Subject: FW: Mistletoe Farm Horsemere Green Lane Climping BN17 5QZ - CM/72/21/DOC

The environmental health officer has made the following comments regarding the Electric Vehicle charging points.

PROPOSED CAR CHARGING PLAN
(1:100)

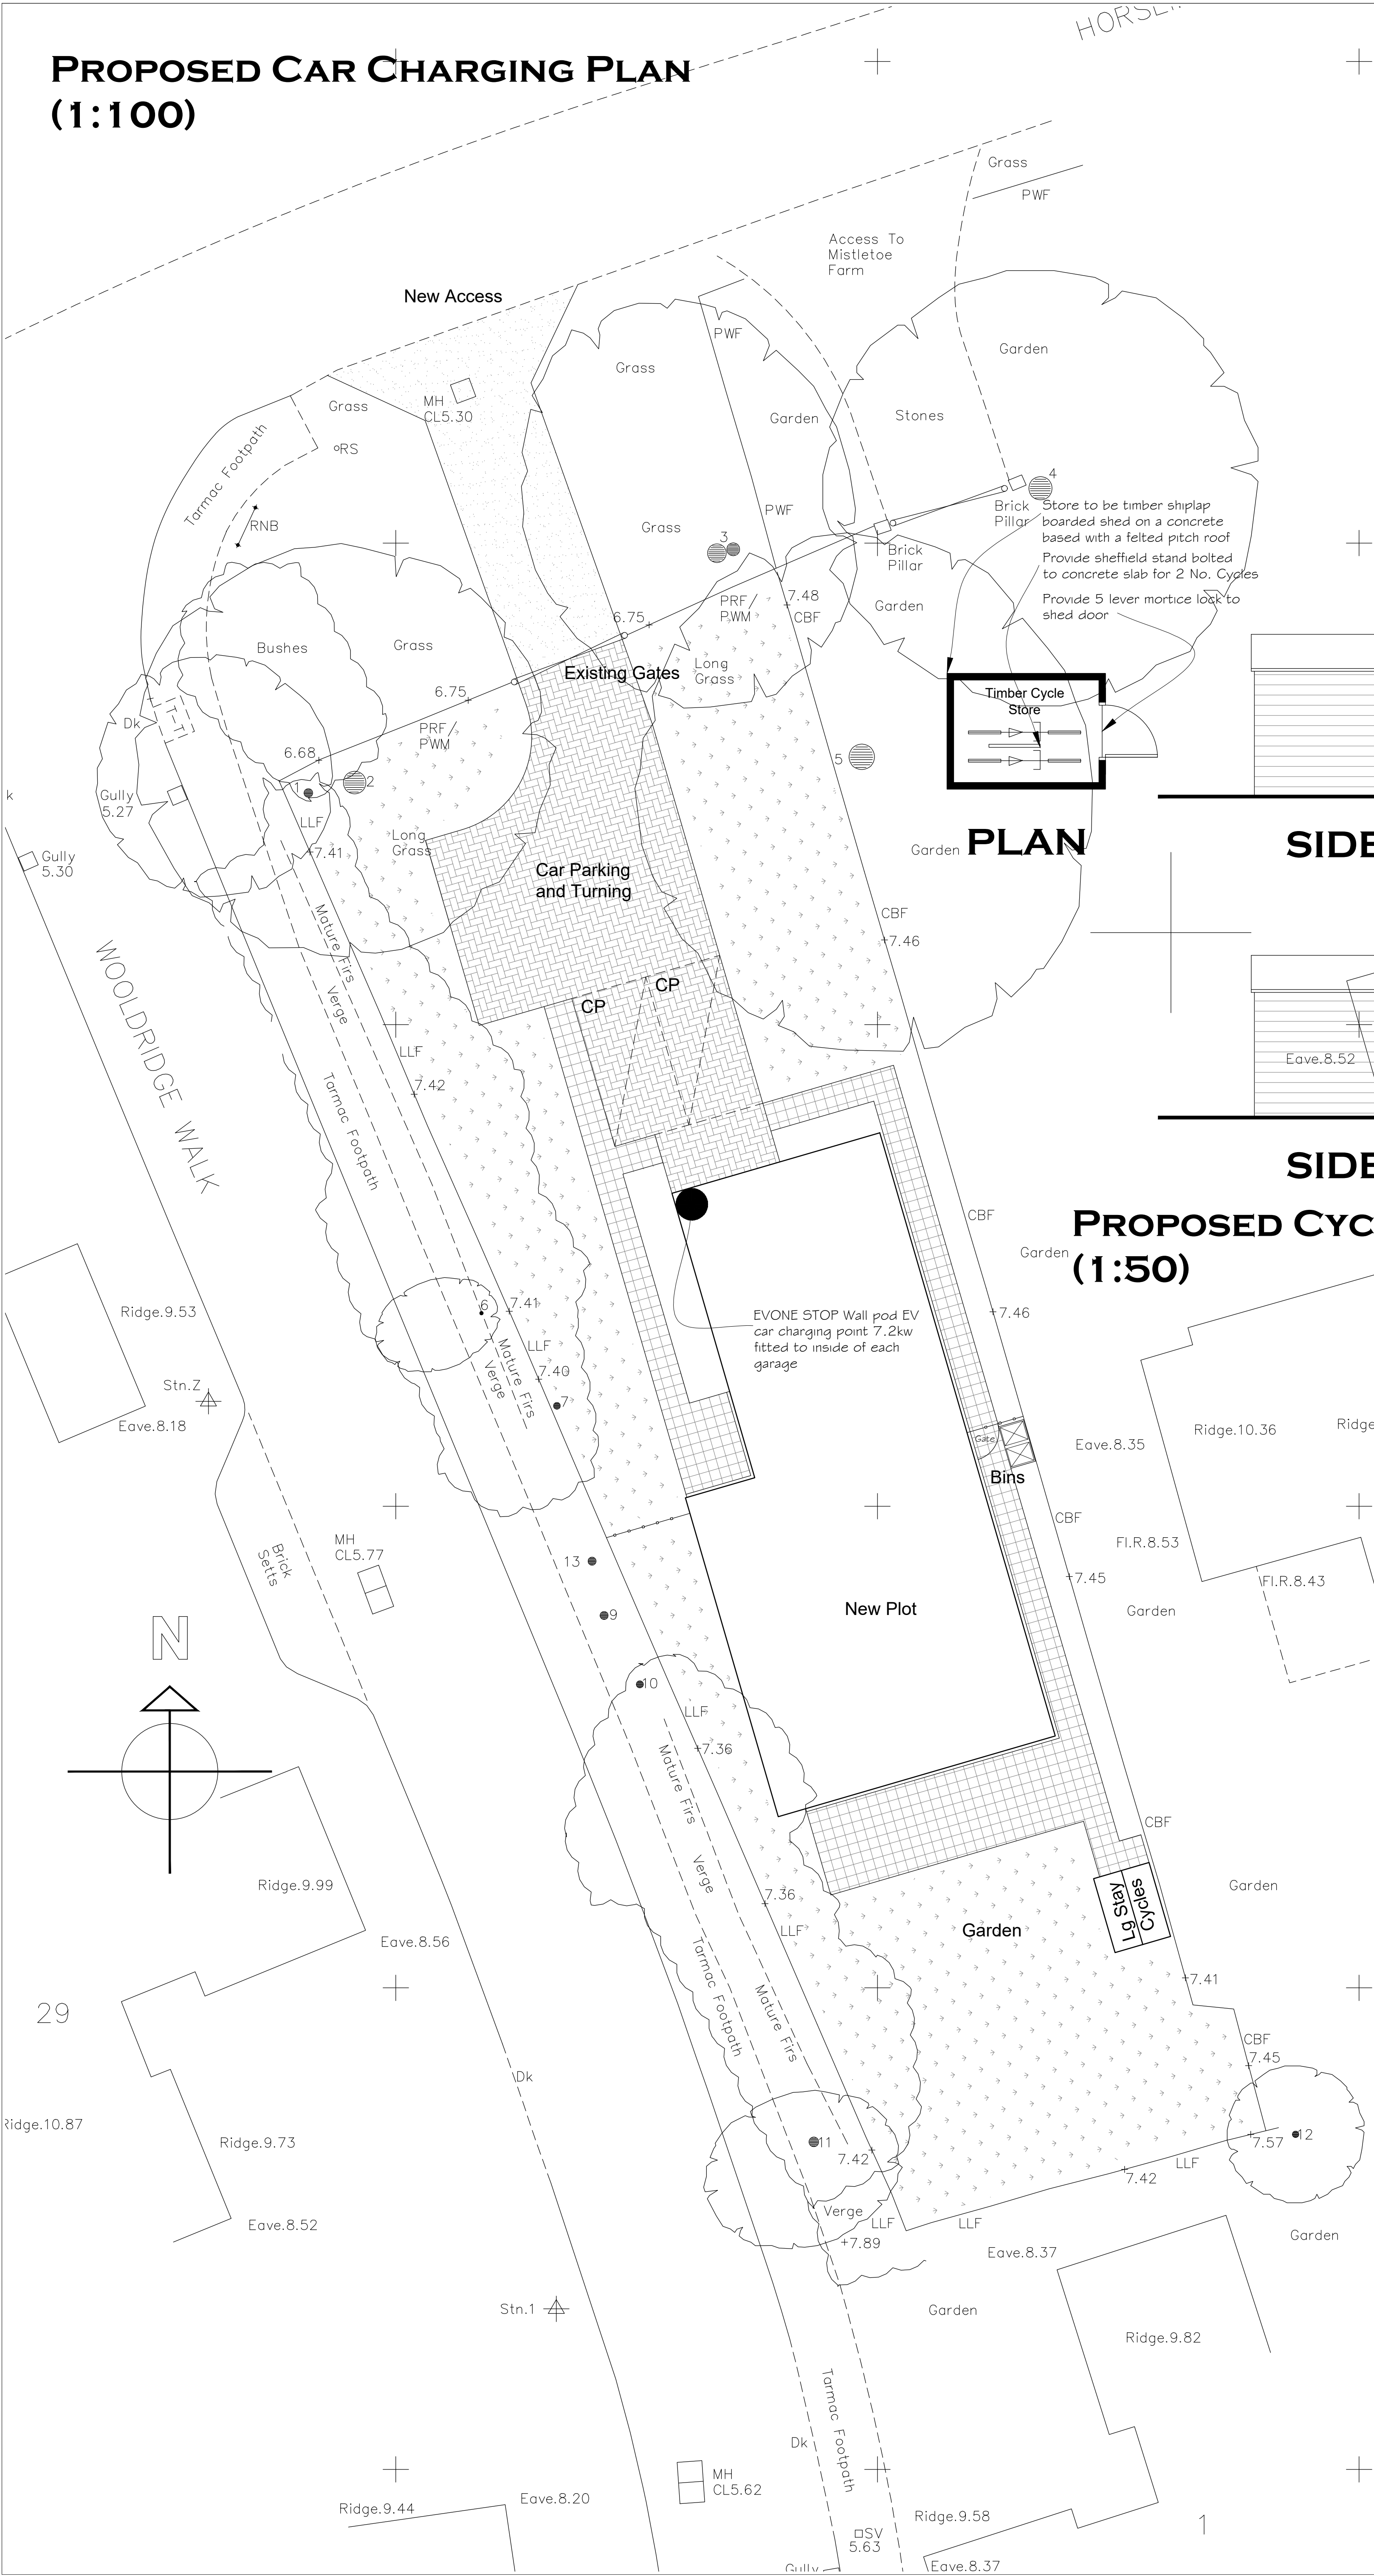
Having reviewed the document entitled 'Wallpod:EV | Free to use | Type 2, Mode 3 Charging Socket 3.6kW or 7.2kW'. I note the product codes to include EVWP 2010, EVWP 2016, EVWP 2020, EVWP2026. These models do not appear on the government's database of electric vehicle home charge scheme approved model list. As the model does not appear on the home charge list this indicates the proposed model is more suited to commercial

applications. I therefore request the applicant provides a model which appears on the government database of electric vehicle home charge scheme approved model list.
